Preliminary and Final DRAINAGE PLAN AND REPORT **ROCKY TOP MOTEL AND CAMPGROUND**

County File No.: PPR2140

EPC STORMWATER REVIEW COMMENTS
IN ORANGE BOXES WITH BLACK TEXT

SUBJECT: Drainage Plan and Report
Rocky Top Motel and Campground

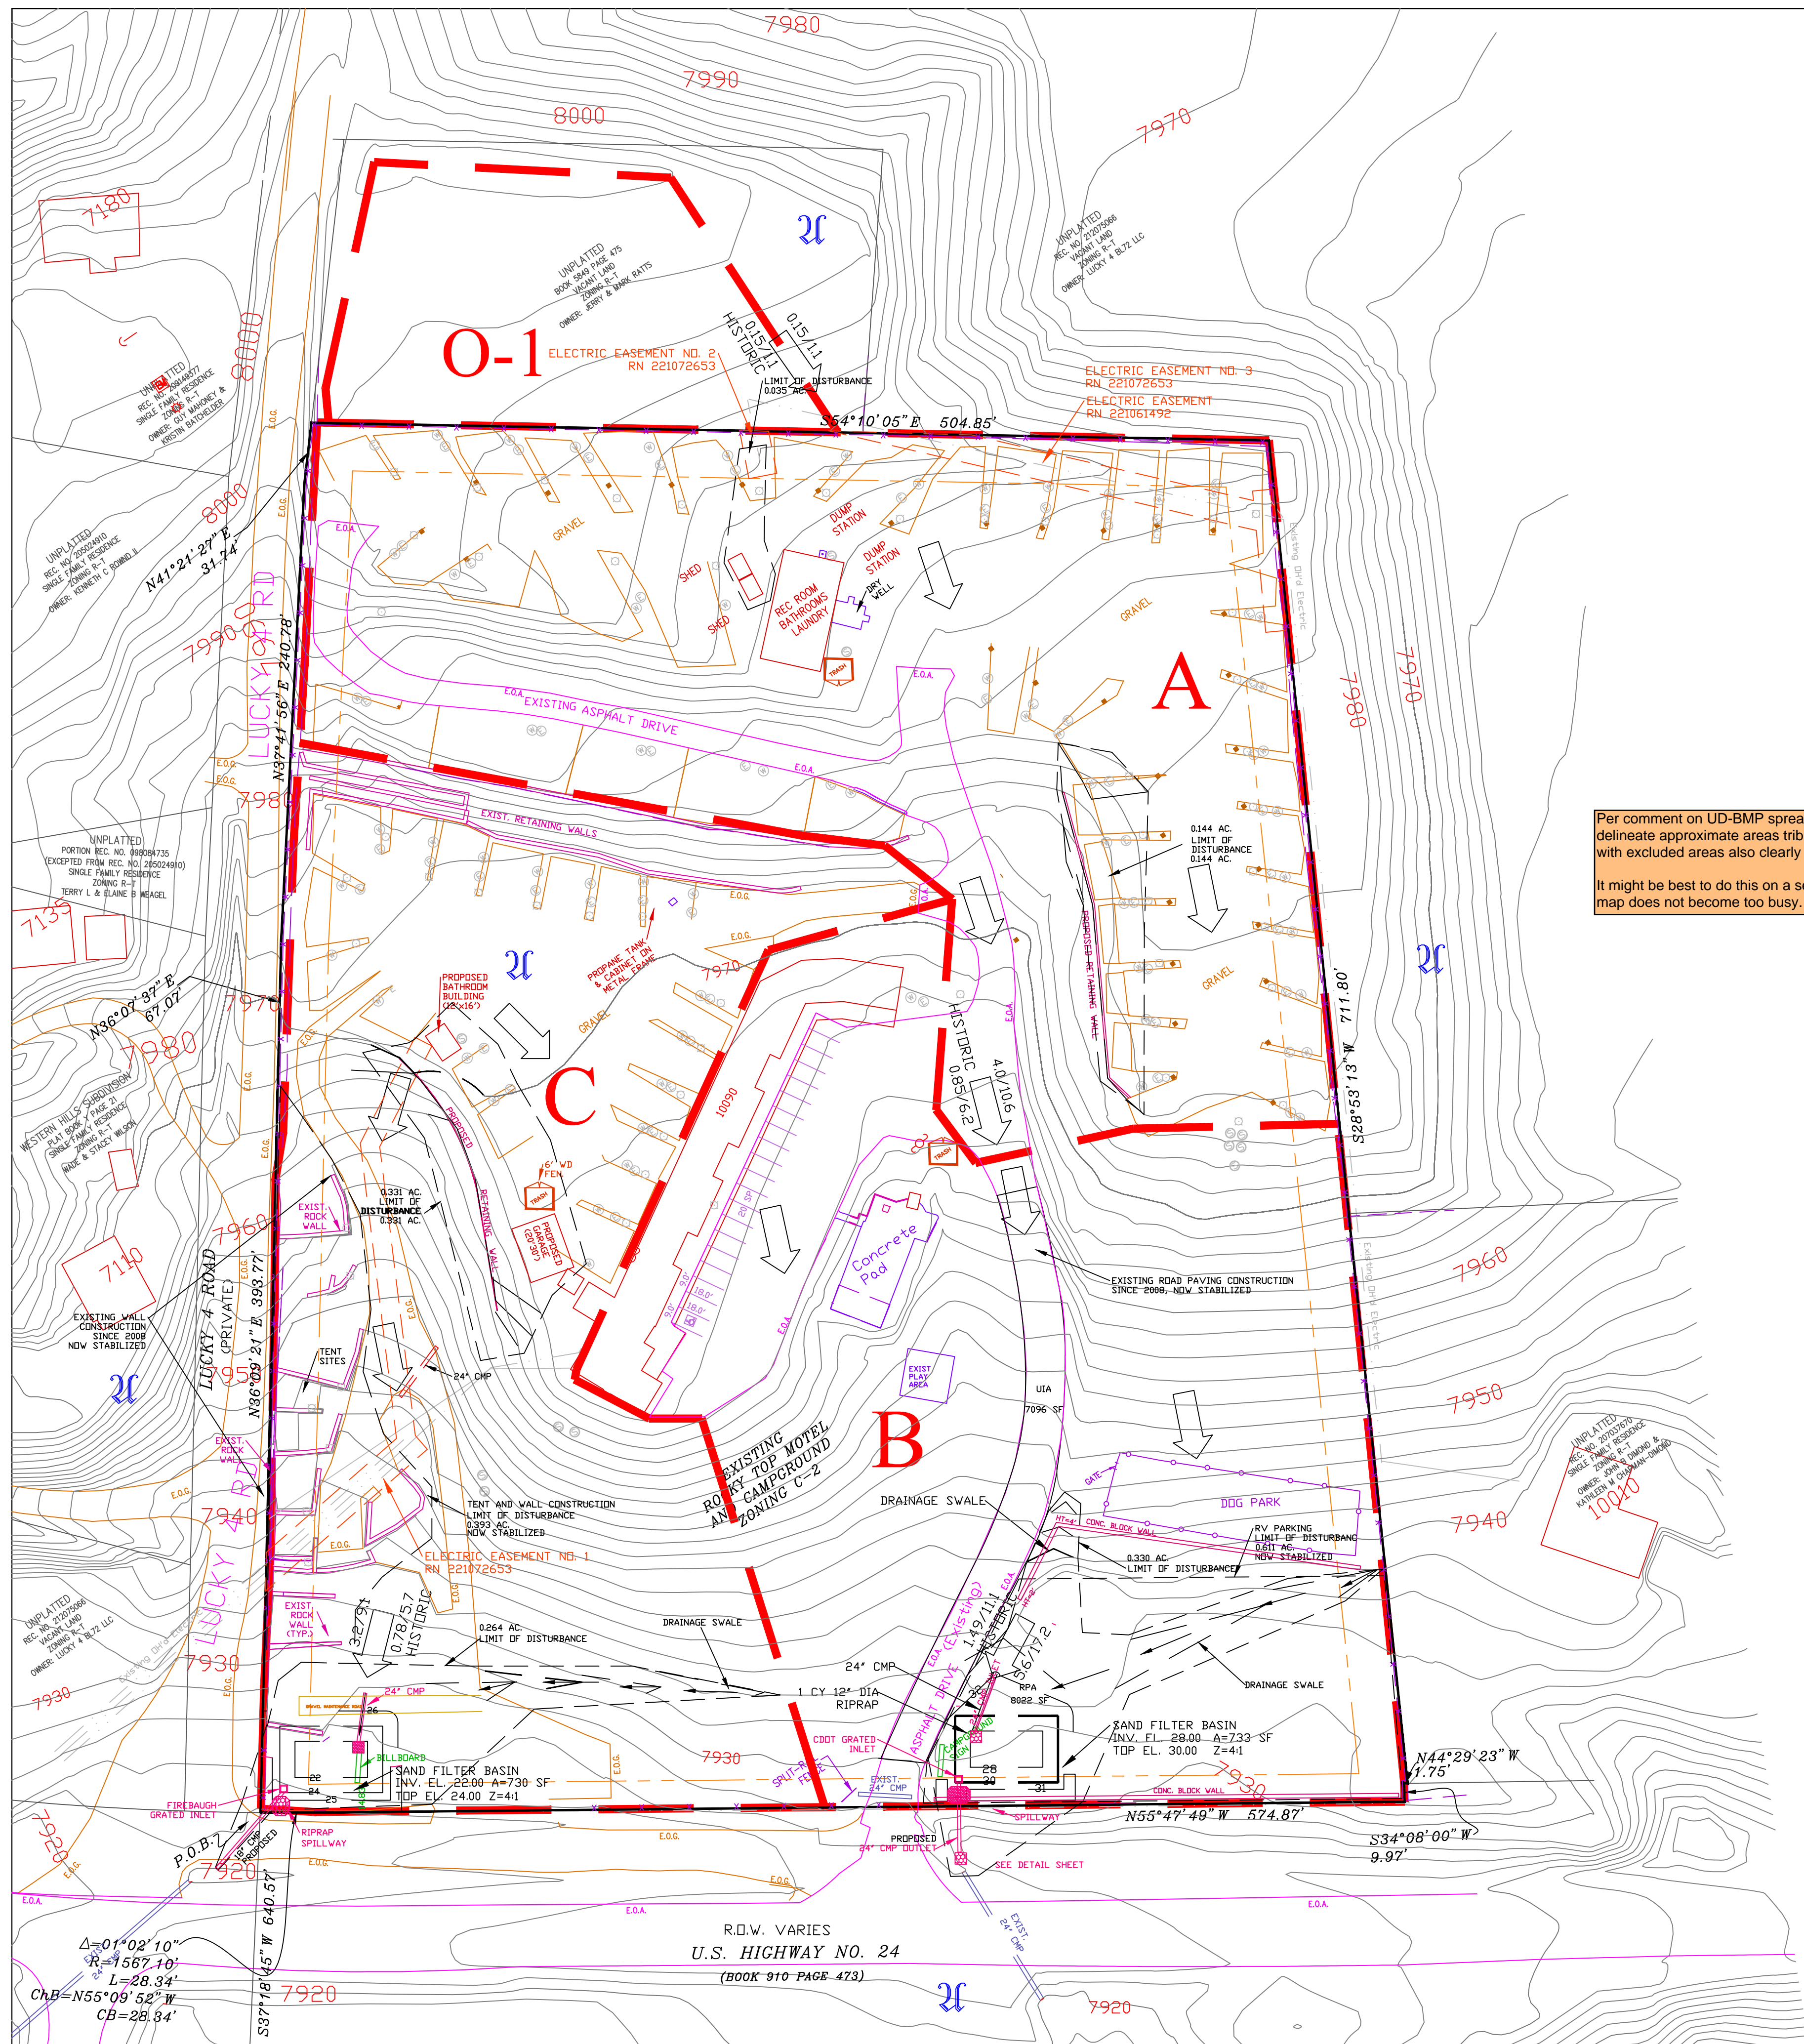
Please state whether or not the offsite flow was reverted to historic conditions by the addition of this retaining wall. If not then please analyze the conveyance to the outfall to ensure it is adequate.

Please clarify which culvert this is on the drainage map.

Delineate this area on the drainage map. It doesn't appear that the flows from the paved road (that need to be treated) are tributary to the pond. So we need to see this delineation in order to confirm which areas are being treated and are apart of this 129,700sq ft that is listed on this spreadsheet. See comment on page 6 above about possible exclusions. All areas within the LOD and/or disturbed since 2008 will need to with be shown as tributary to one of the ponds are shown to have an appropriate exclusion apply.

1.5ft here does not match what is shown on the plans. The plans show the bottom of the pond at 22ft elevation and inv of 4" pipe at connection to 18" pipe at 20.74ft. So something isn't right. Revise calcs and/or plans as needed to remove this discrepancy.

ALL TERRAIN RESPONSE: ADDRESSED. EXISTING CULVERTS ARE NUMBERED ON MAP AND THROUGHOUT CALCS/REPORT.

ALL TERRAIN RESPONSE: NOT
ADDRESSED. SAND FILTERS NO
LONGER PROPOSED. OFFSITE
BASIN TO CHECK CULVERT #2
IS NOT ACCESSIBLE TO RECEIVE
TOPO. THEREFORE, FLOW TO
CULVERT #2 IS NOT
DEFINABLE. HOWEVER, ONSITE
INCREASE TO CULVERT #2 IS
NEGLECTABLE. SEE UPDATED
REPORT TEXT REGARDING.
